CITY OF ALBUQUERQUE

February 7, 2022

**RE: Saranam Golf Course & Montano
4701 Montano Rd NW
Grading and Drainage Plan
Engineer's Stamp Date: 1/4/2022
Hydrology File: E11D013B**

Based upon the information provided in your submittal received 1/4/2022, the Grading & Drainage Plan is **not** approved for Building Permit. The following comments need to be addressed for approval of the above referenced project:

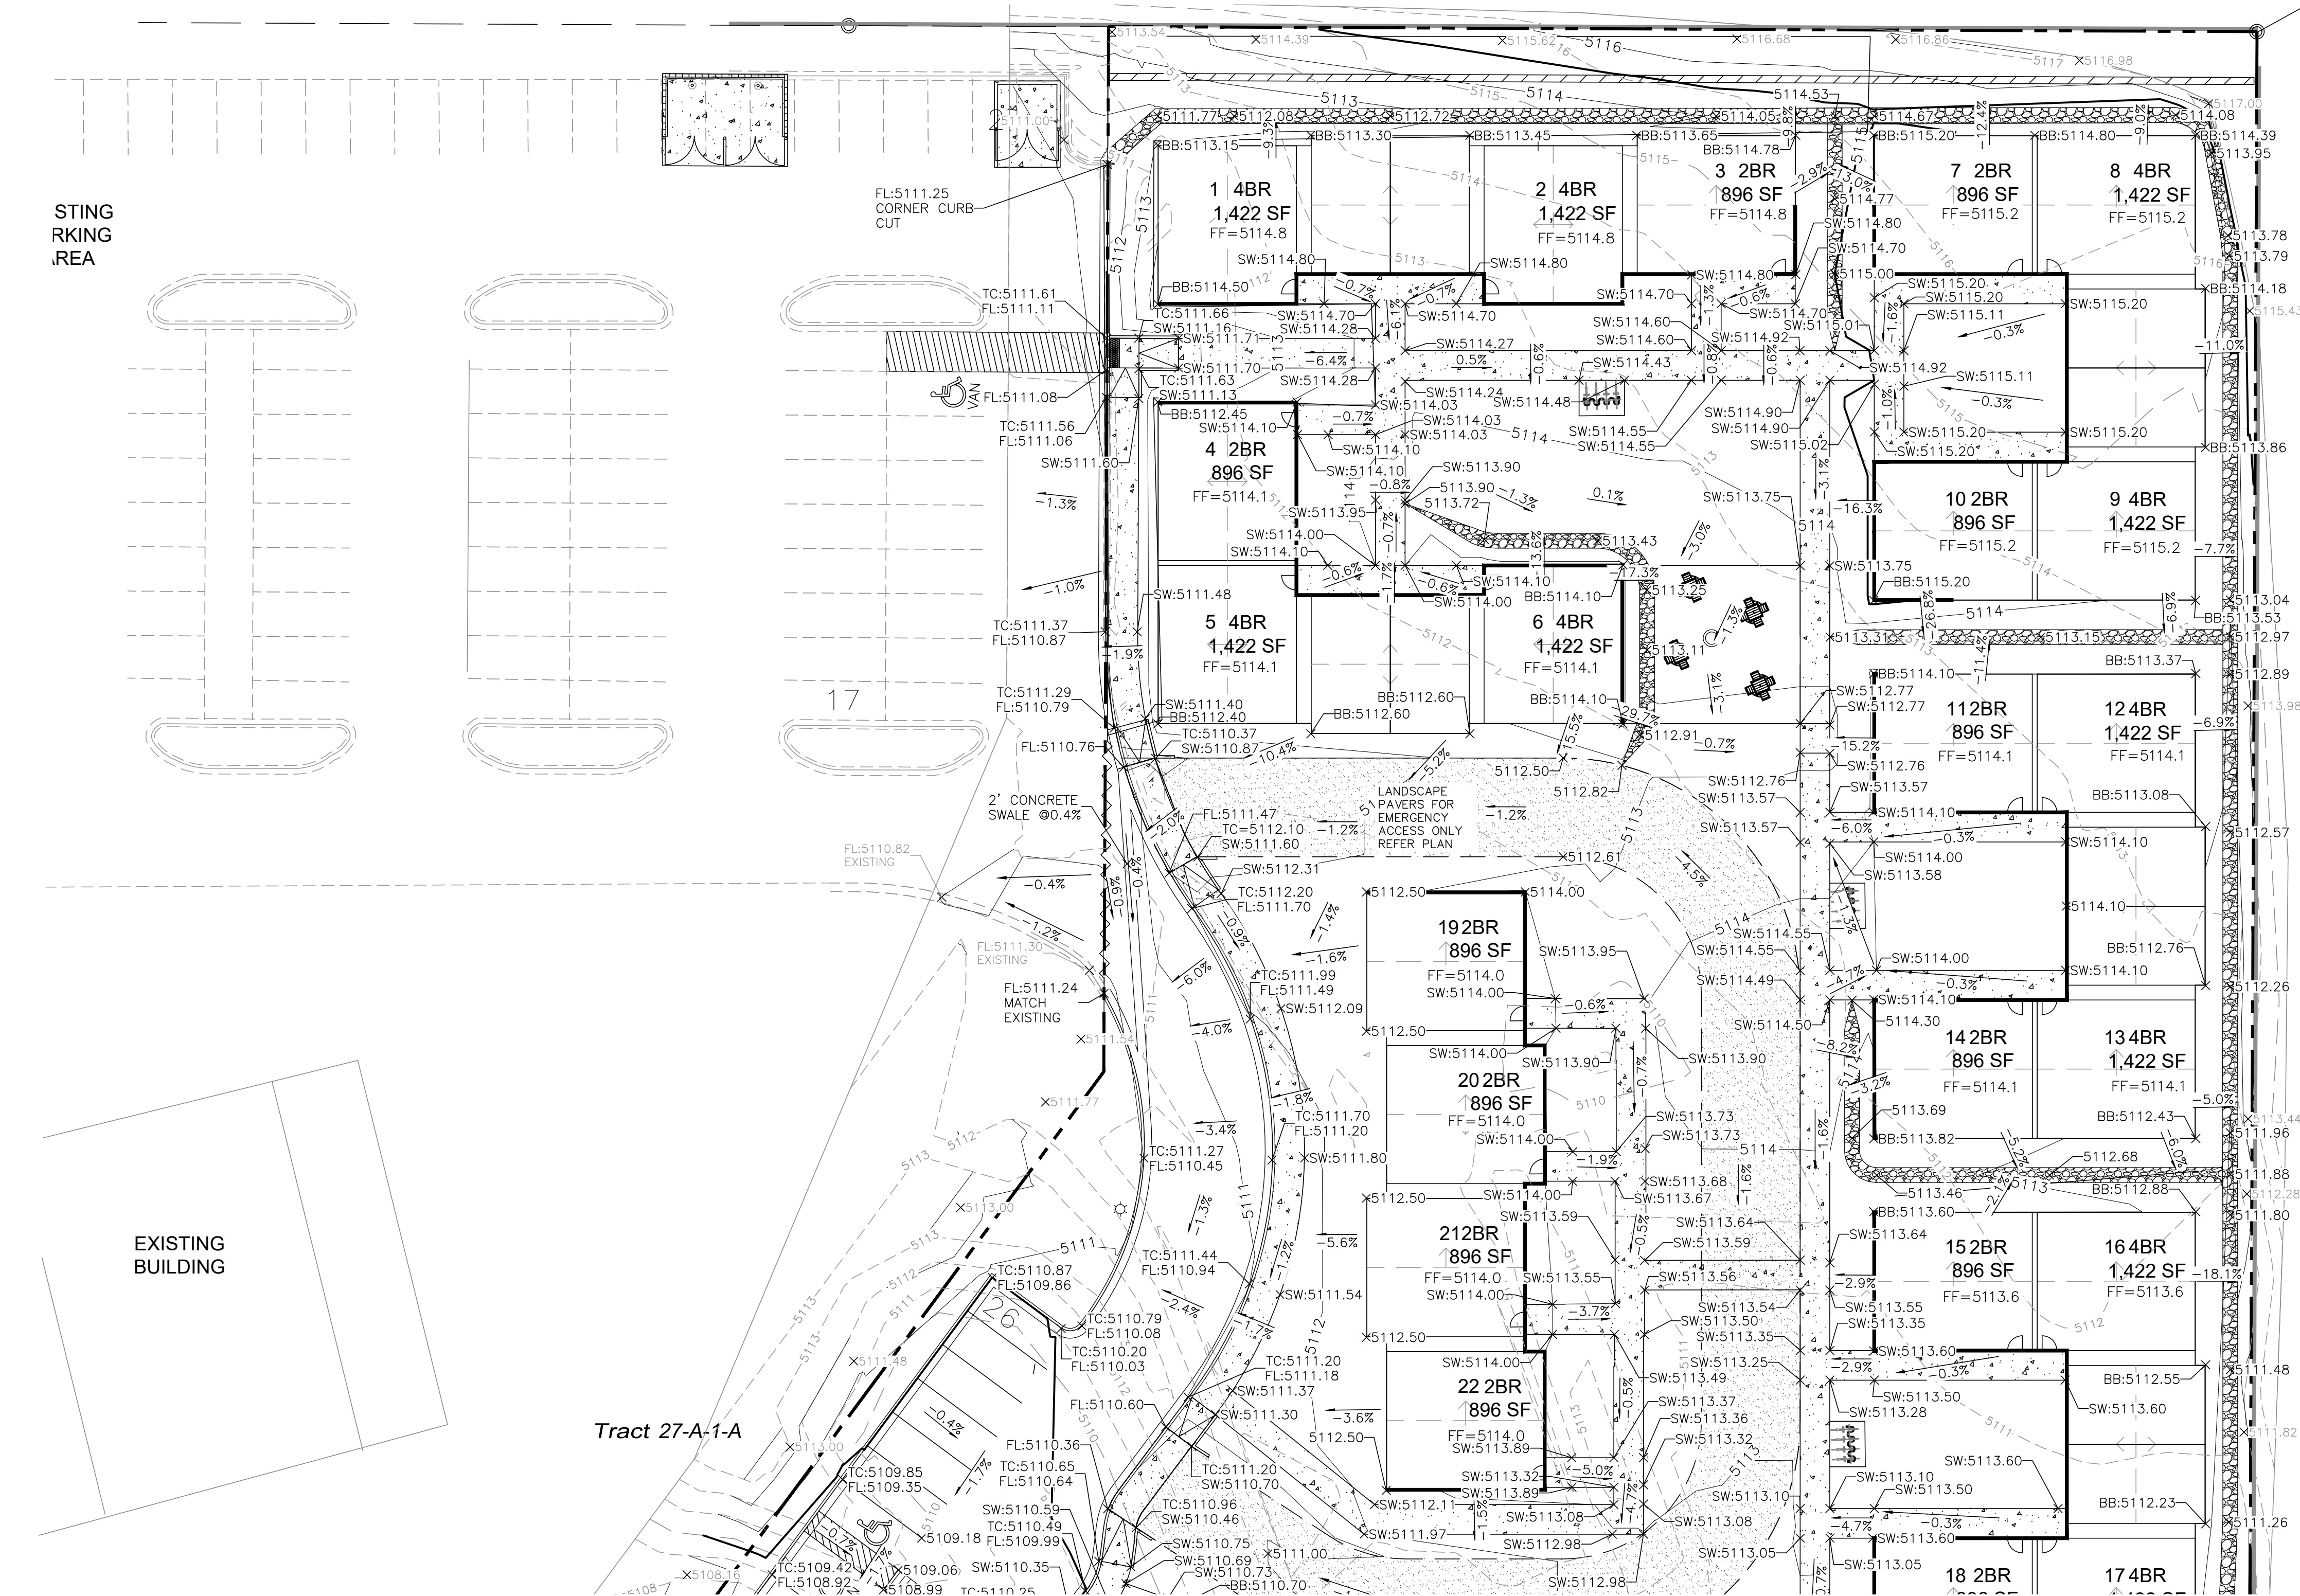
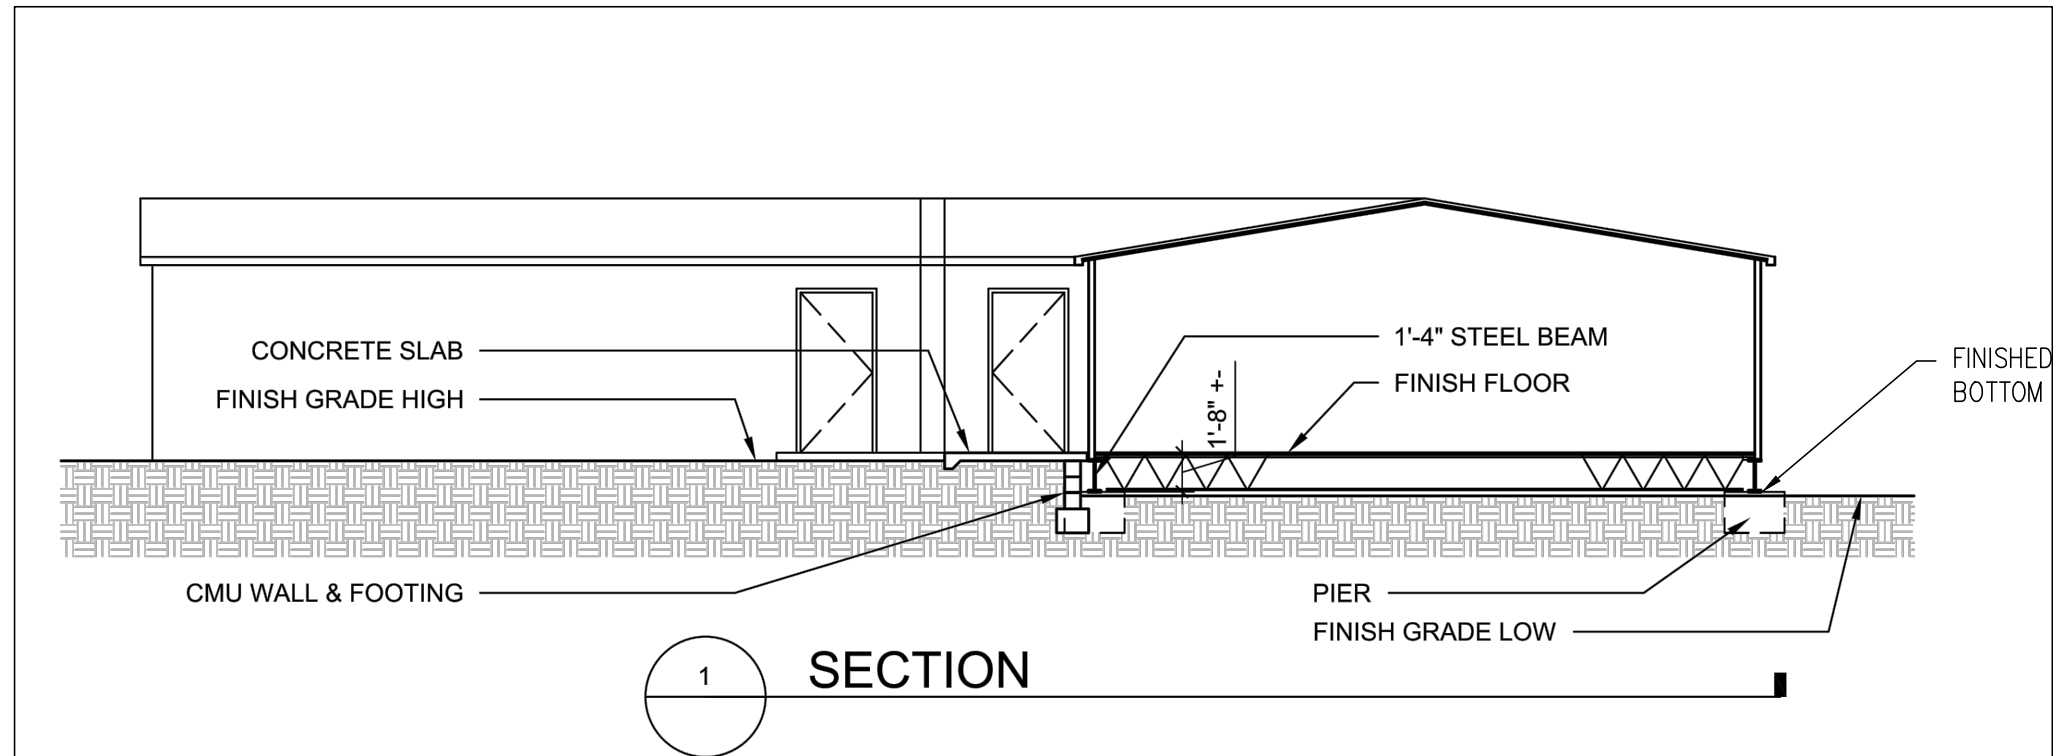
SHEET C2.3

3. Check this area. Appears maybe some ponding and may flow right to the doorway area here.

- a.
4. Is this a water block? If so, please provide elevations showing how these grades will work and ensure flow does not drain across lots.

- a.
5. Where does this flow end up? Cross lot drainage?

- a.
6. Check all pads. They should be higher than surrounding grade.

7. How will this work? Will there be a pipe under sidewalk?

- a.
- b. Please show all of these details. As of now it appears this is just a ponding area.
